<b>Application Ref:</b>	3/2020/1036	 <b>Ribble Valley Borough Council</b> <a href="http://www.ribblevalley.gov.uk">www.ribblevalley.gov.uk</a>
<b>Date Inspected:</b>	07/01/2021	
<b>Officer:</b>	RB	
<b>DELEGATED ITEM FILE REPORT:</b>		<b>REFUSAL</b>

<b>Development Description:</b>	Proposed 2no single storey rear extensions, replacement of existing garage out building, two dormer windows on the rear elevation and alterations to shop front to provide separate entrances to the shop and flat above.
<b>Site Address/Location:</b>	46 Eshton Terrace Clitheroe, BB7 1BQ

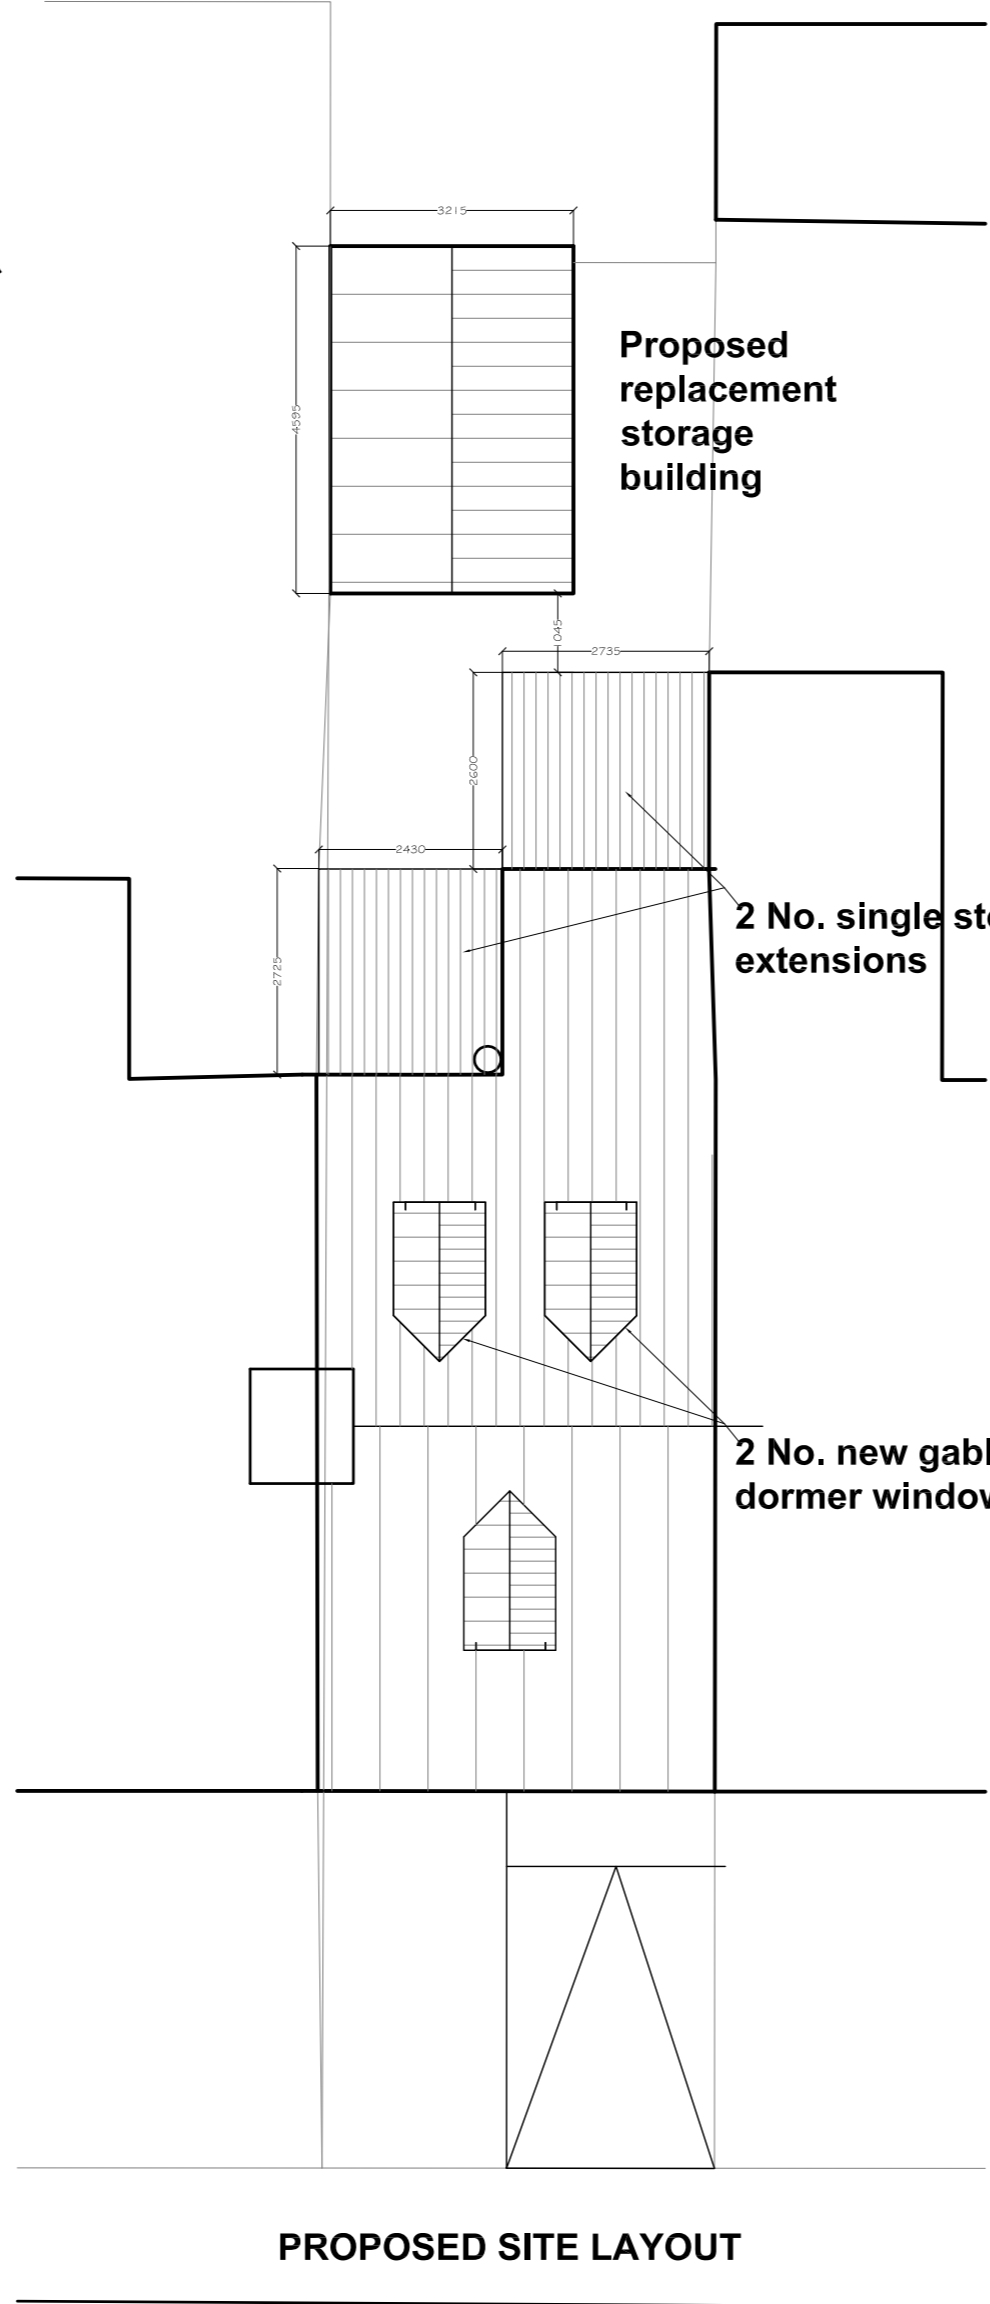
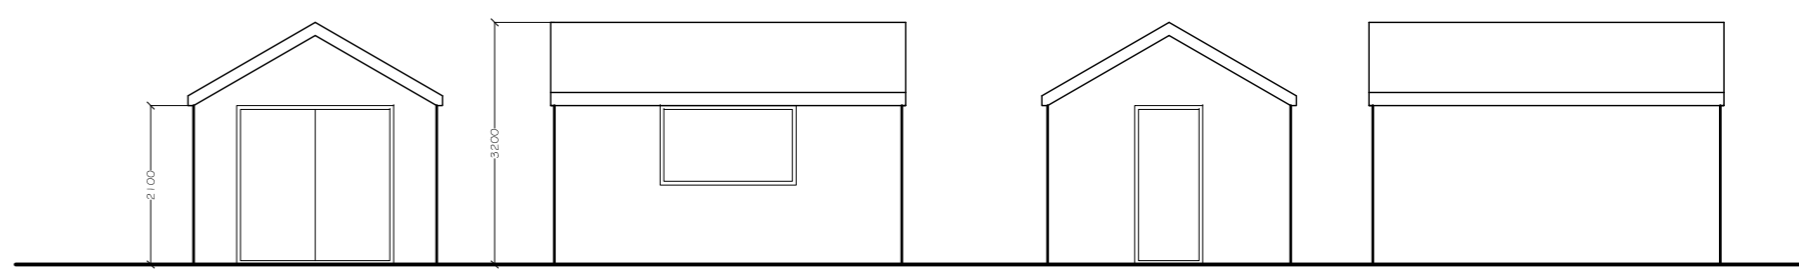
The proposed pitched roof outbuilding will be set on the boundary between no 46 and 48 Eshton Terrace. The proposed outbuilding will be approximately 2.1m in height to the eaves with a pitched roof measuring at 3.5m. Whilst the proposed outbuilding has increased in height when compared to the existing outbuilding it is considered that due to the separation distance between the rear elevation of the neighbour, no 48 Eshton Terrace and fact that the building will be sited on land lower than the ground level of the rooms in the neighbouring property the development would not result in a detrimental loss of light to this neighbour.

The rear boundary of the site is visible from within Clitheroe Castle Park and therefore both the rear single storey extensions, and outbuilding will be visible from a public viewpoint from within the designated Conservation Area and could also potentially impact on the setting of Grade I listed Clitheroe Castle. The significance of the terrace block is derived from the strong rhythm in window opening arrangement and proportions (single vertically emphasised window at both ground floor and first floor in each bay – no 50 retains a mid late C19 2/2 vertically sliding timber sash in the later brick-built extension. It is considered that the outbuilding will not be viewed as inappropriate addition as the garage is single storey and is relatively set back from the rear boundary and would not have a detrimental impact on the setting of Clitheroe Castle or character of Clitheroe Conservation Area.

The proposed rear extensions are inappropriate and would be result in incongruous additions that would result in less than substantial harm to the character of Clitheroe Conservation Area and therefore in accordance with Paragraph 196 of the NPPF this harm should be weighed against the public benefits of the proposal. The applicant's agent has not identified any public benefits to the proposal only that the approval would allow the applicant to expand there business therefore the only benefits of the proposal would be private.
